**Re: Mercado El Milagro, Building G at 10,000 Central Ave SW  
Erosion and Sediment Control Plan  
Engineer's Stamp Date 5/5/2023 (L09E042B)**

Based upon the information provided in your submittal received 5/5/2023, the ESC Plan cannot be approved for Building Permit until after the following comments are addressed.

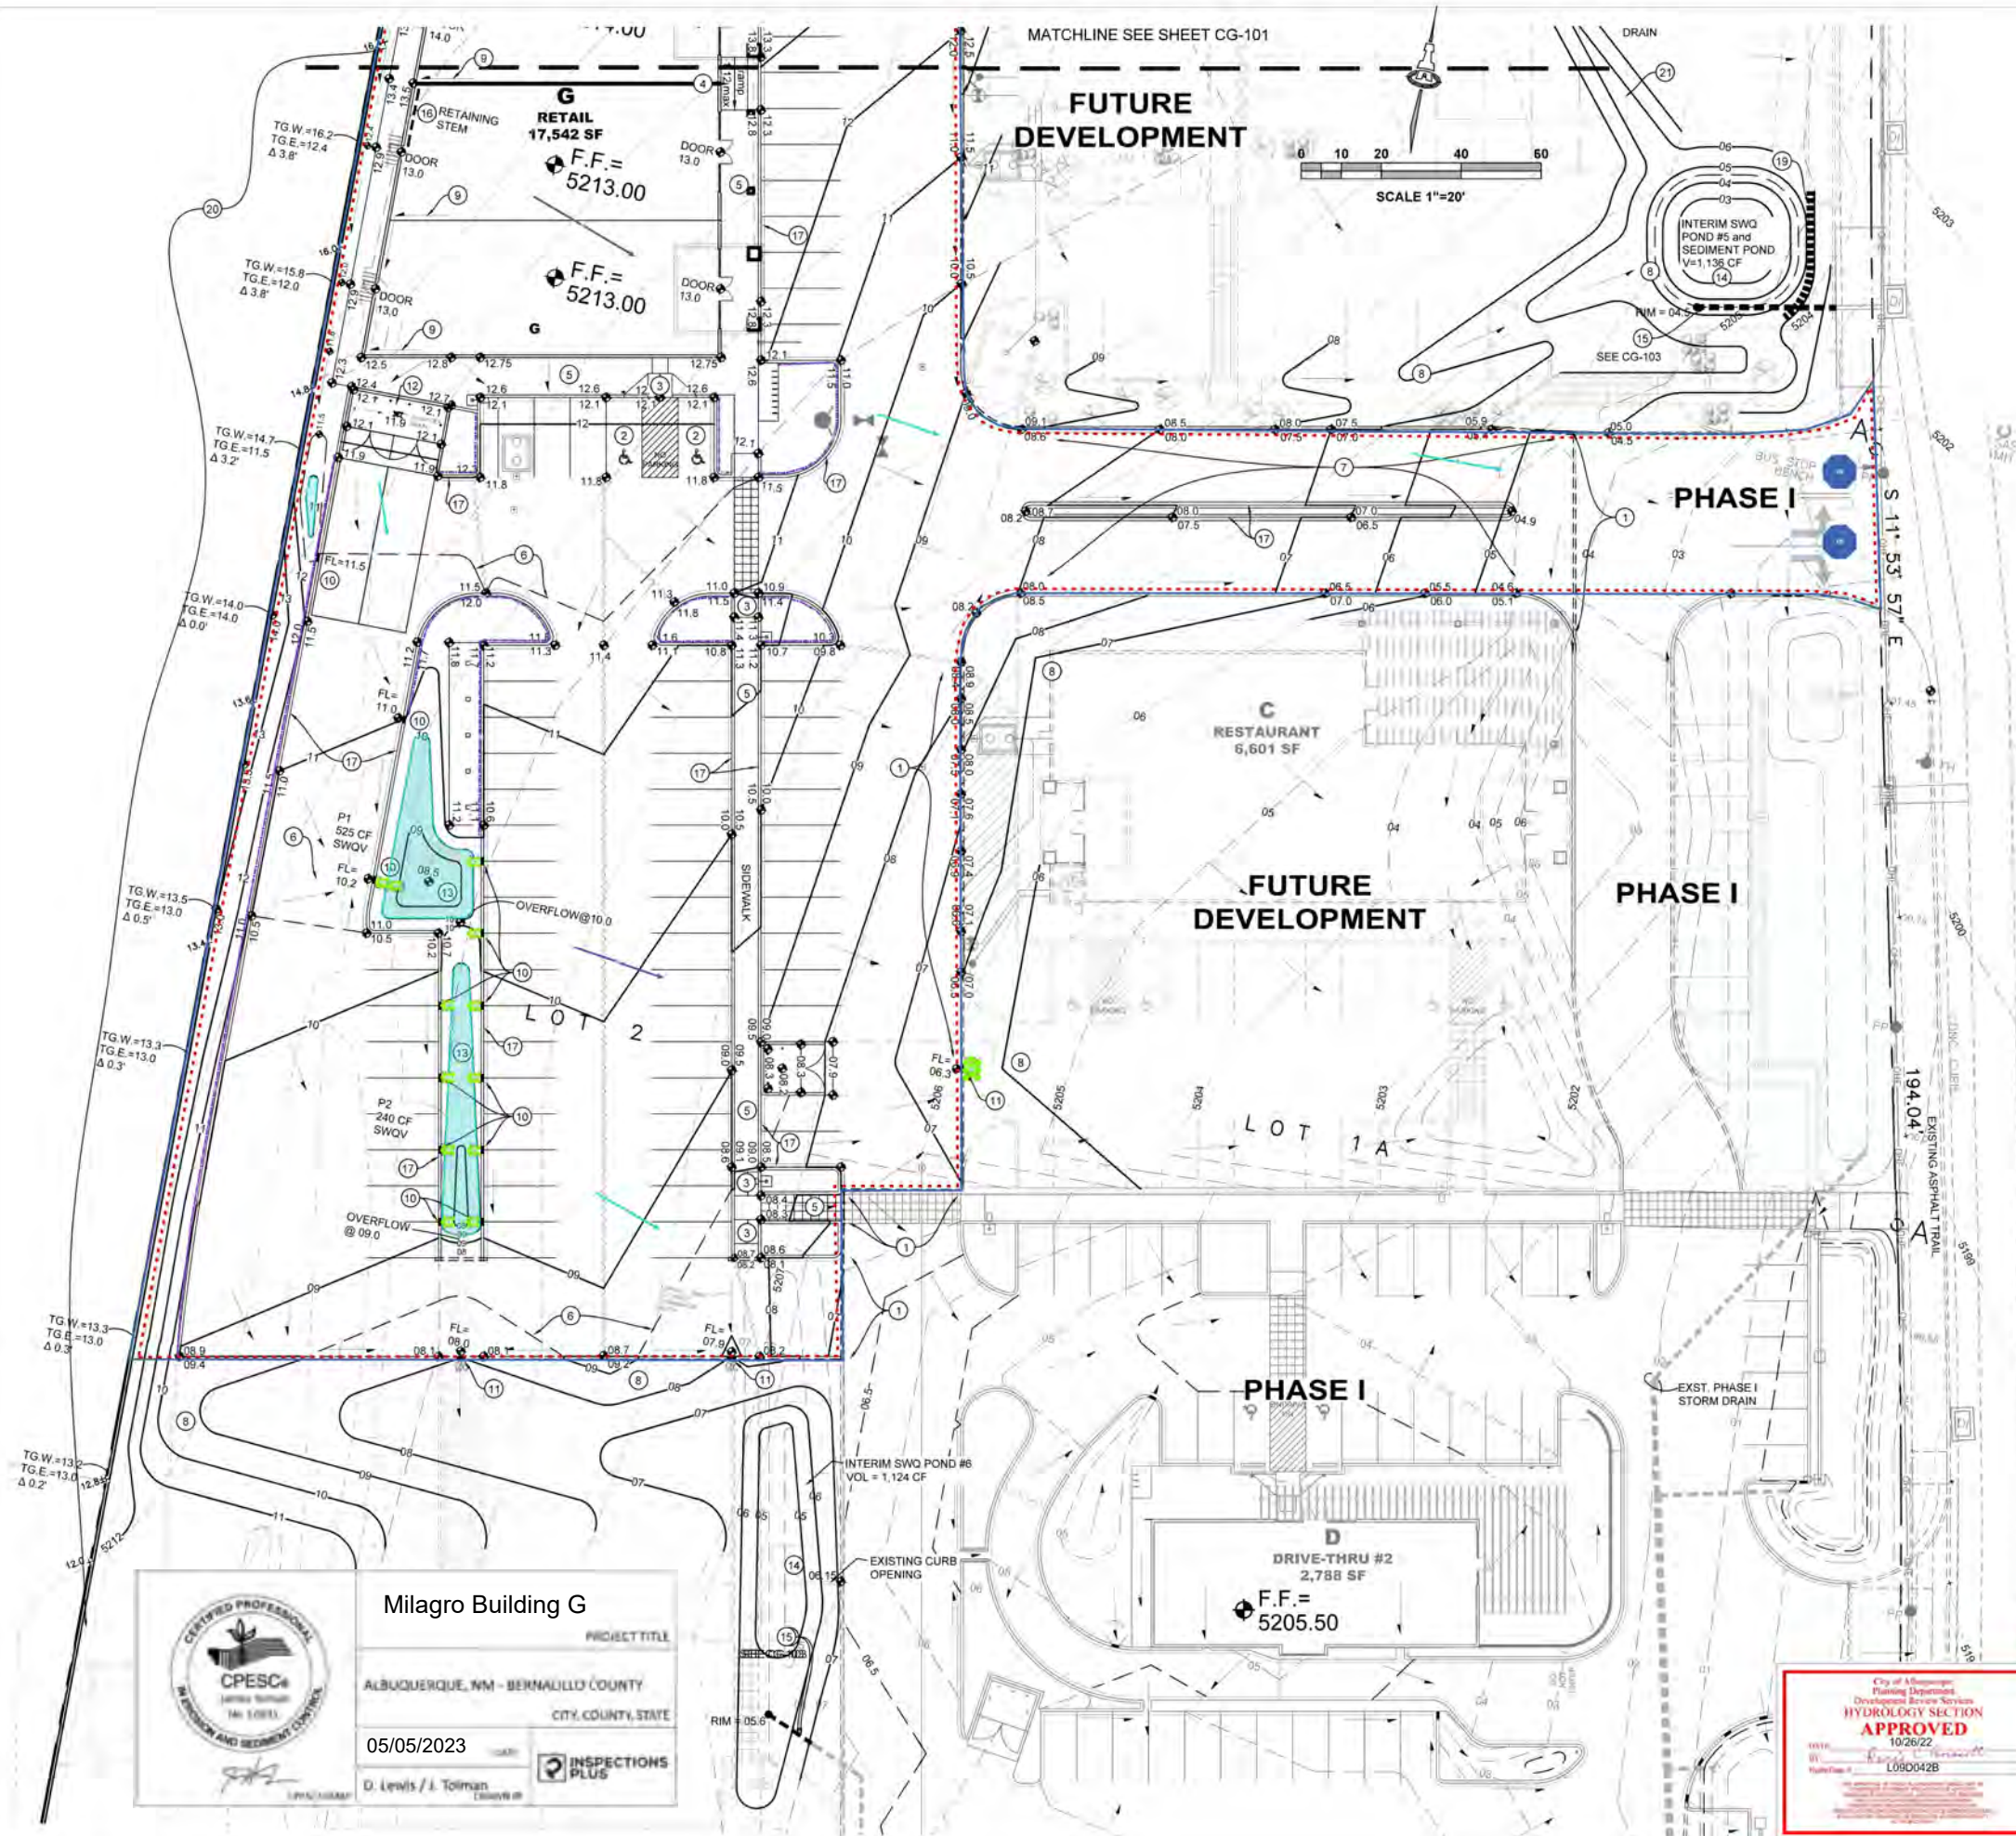
1. The ESC Plan must show the Property Boundaries per CGP 7.2.4.a and the Limits of Disturbance per CGP 7.2.4.b. The legend on the ESC Plan shows a blue line labeled "Property Boundary and Limits of Disturbance" but the location of the blue line shown on the ESC Plan is neither at the property boundary nor at the limits of disturbance on the south and east sides of the site. The proposed grading contours extend beyond the limits of disturbance as shown, so the limits of disturbance should be moved to the limits of the proposed grading contours. The limits of disturbance should also include any stockpiles or construction support activities.

3. Perimeter controls (Silt Fence) is required per CGP 2.2.3 and must be shown on the ESC Plan at the new location of the limits of disturbance.

SHEET NO:
L1.2
4 OF 14

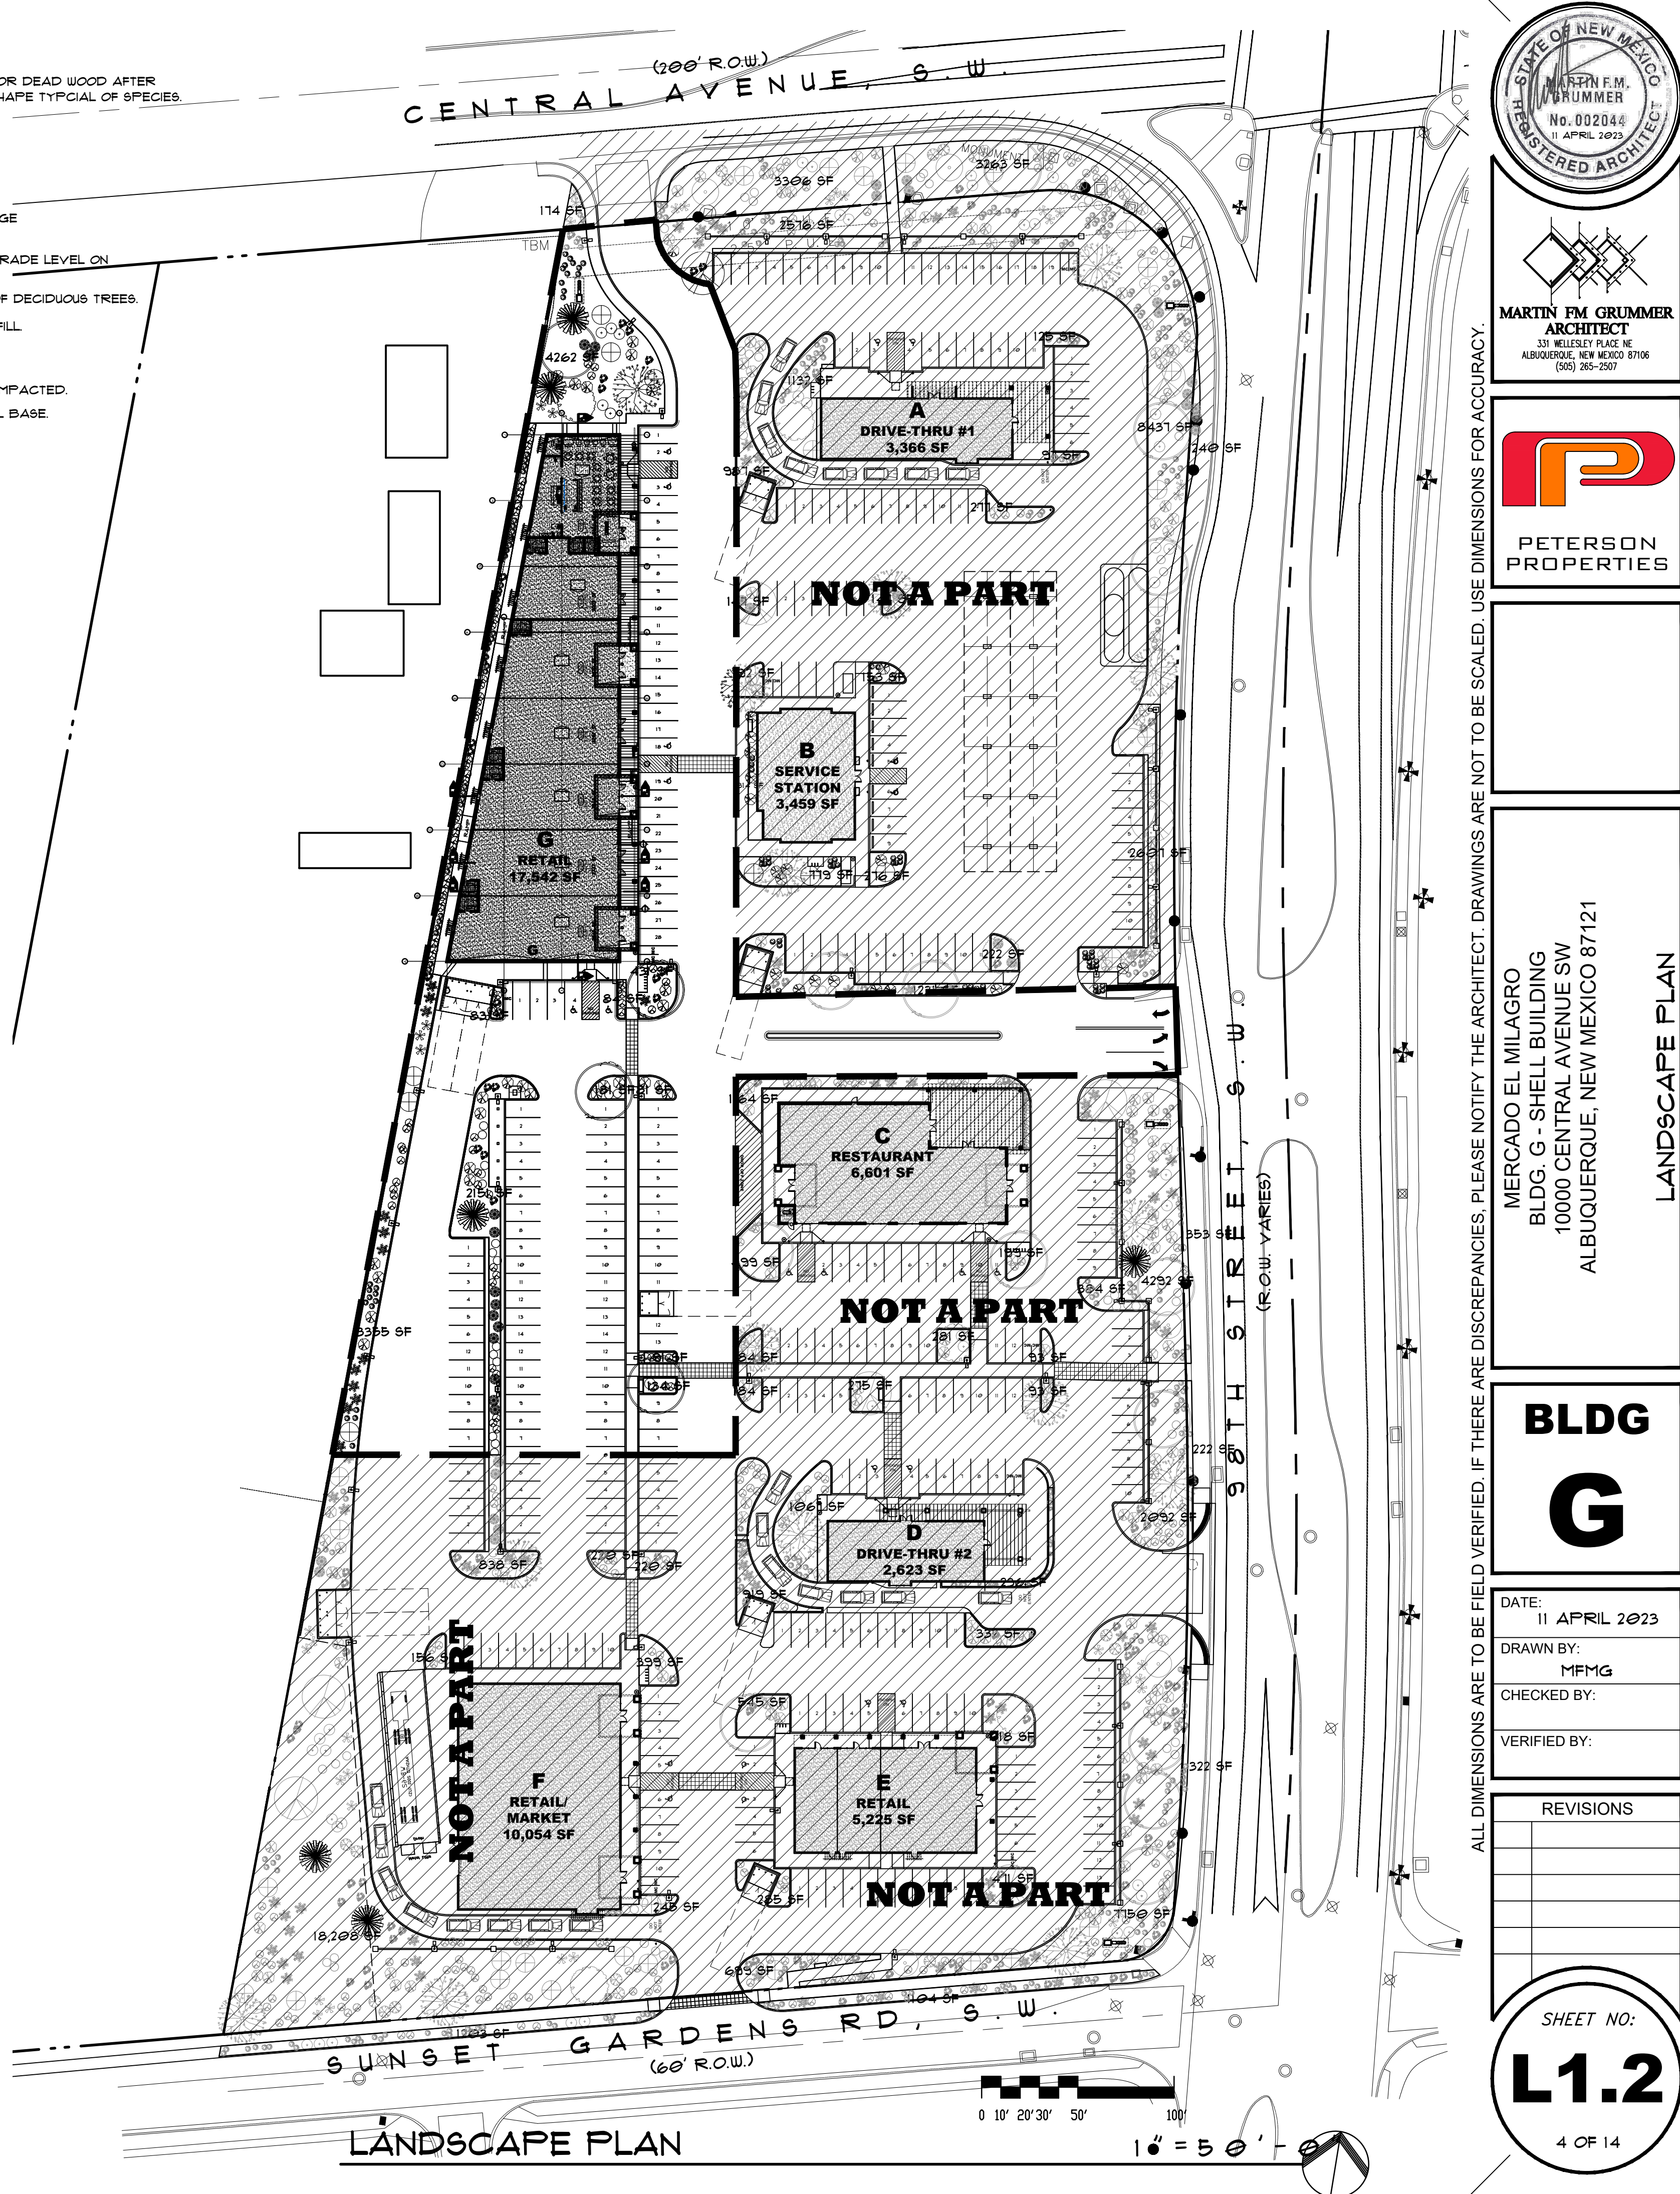
2. The landscape plan shows future development in several of the areas that will be graded with this project. Final Stabilization specifications are required in all areas of land disturbance per CGP 9.4.1.c.i. so additional specifications are needed.
